DECISION DELEGATED TO DEVELOPMENT MANAGER

Application No: H01-0210-20 **Applicant:** Mr Cooke

Proposal: Details of external materials, soakaway system for disposal of surface water and external boxes etc (Conditions 3, 5 and 8 of H01-1216-16)

Location: 230 Barrier Bank Cowbit Spalding

Elevation 01 - Front
1 : 100

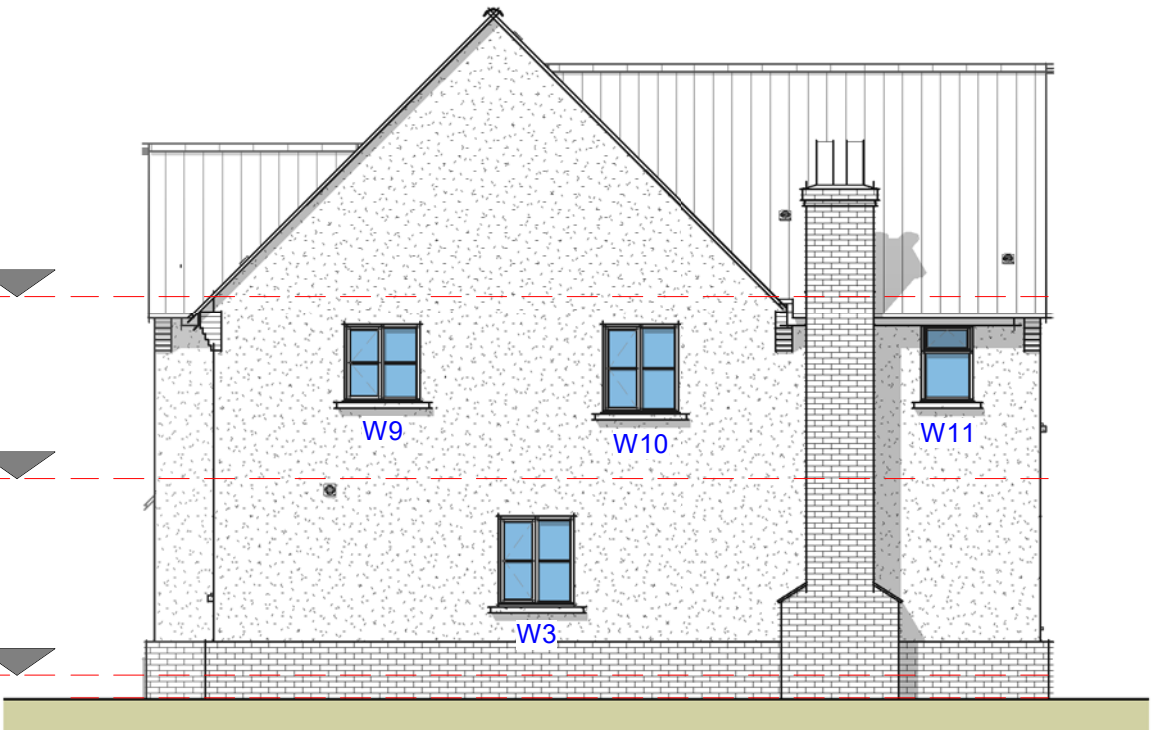
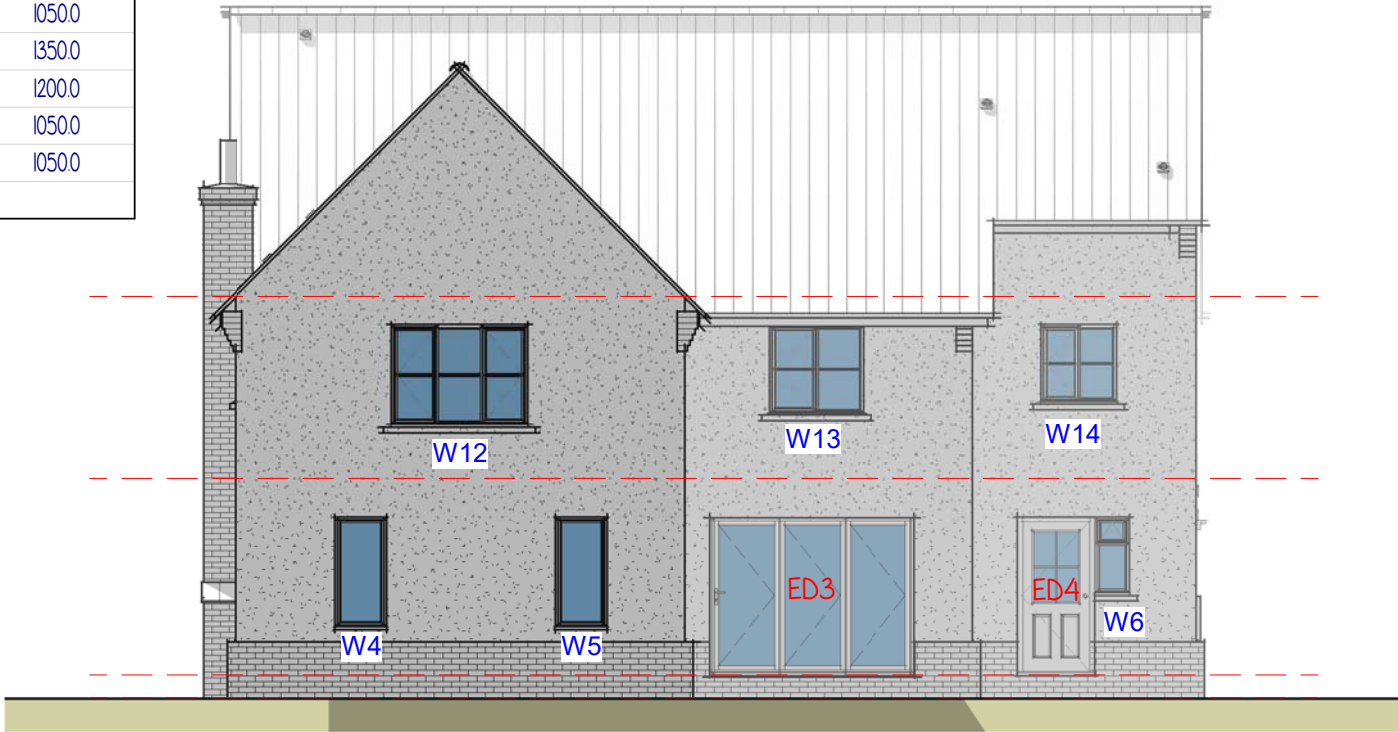
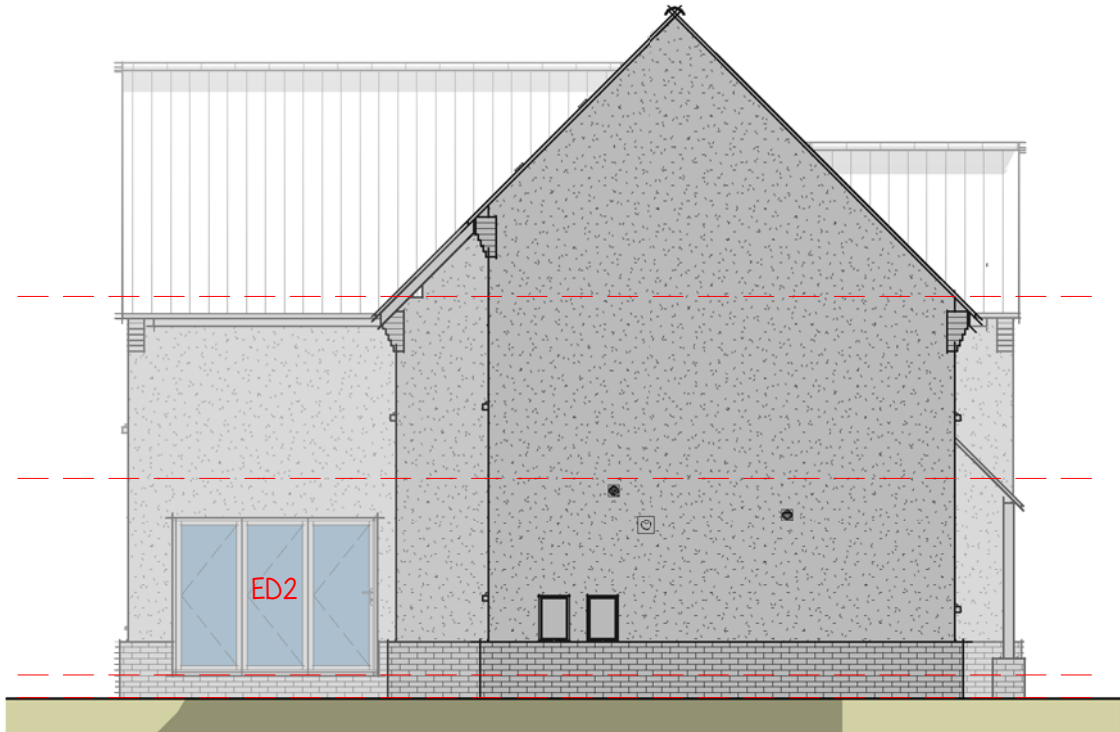
The materials are listed on plan ref 2479/BB/02 rev D and are considered to be acceptable.

| Rev                                                                                                                                                                                            | Date     | Remarks            |
|------------------------------------------------------------------------------------------------------------------------------------------------------------------------------------------------|----------|--------------------|
| Title <b>Proposed Surface Water Drainage Layout</b>                                                                                                                                            |          |                    |

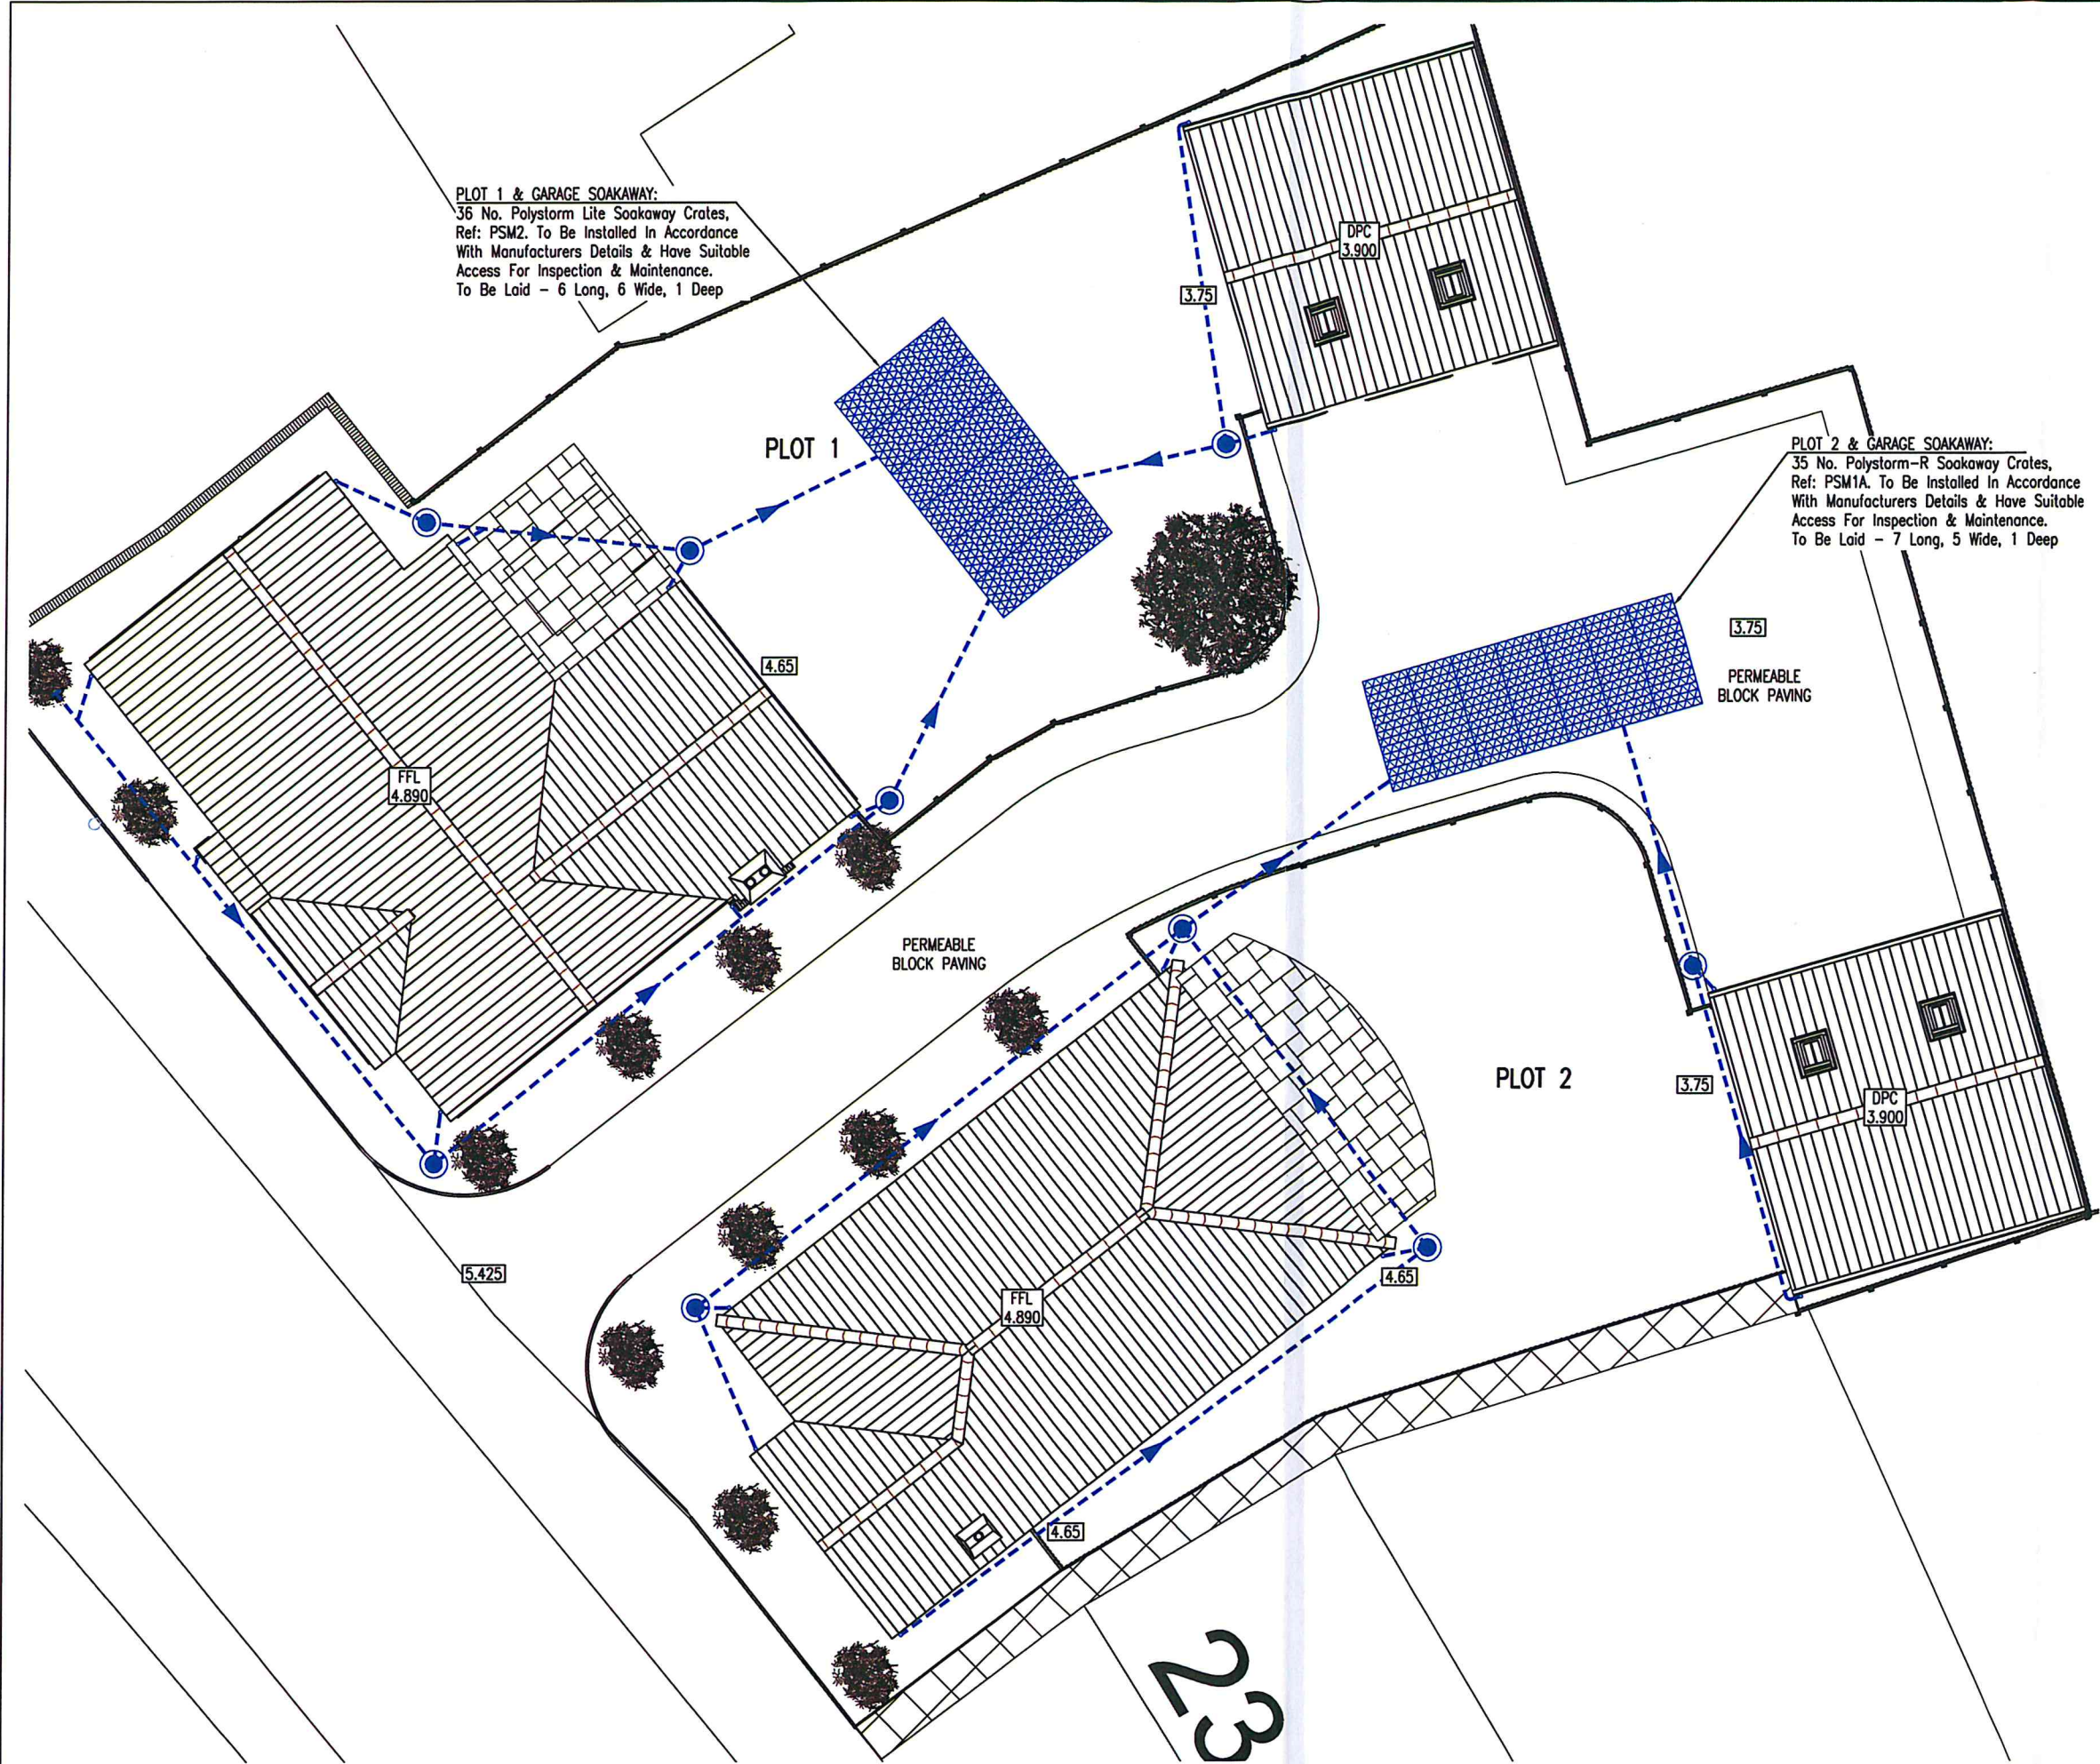
Comments - note that the applicant has indicated that they intend to dispose of surface water via infiltration, however cannot see that the viability of the proposed drainage strategy has been evidenced.

This proposed strategy should be supported by infiltration testing in line with BRE 365 and soakaway design should be in line with SuDS Standards. If (following appropriate testing) a strategy wholly reliant on infiltration is not viable and a surface water discharge is proposed to a watercourse, then the proposed development will require land drainage consent in line with the Board's byelaws (specifically byelaw 3). Any consent granted will likely be conditional, pending the payment of a Surface Water Development Contribution fee, calculated in line with the Board's charging policy.

LCC SUDS raise no objection to the details submitted. The Internal Drainage Board have commented as set out above.

It is considered that given that LCC raise no objection, and the wording of the condition sets out the actions if percolation test results are considered unacceptable, then at present there is no reason to withhold approval of agreement to the details of this submission.
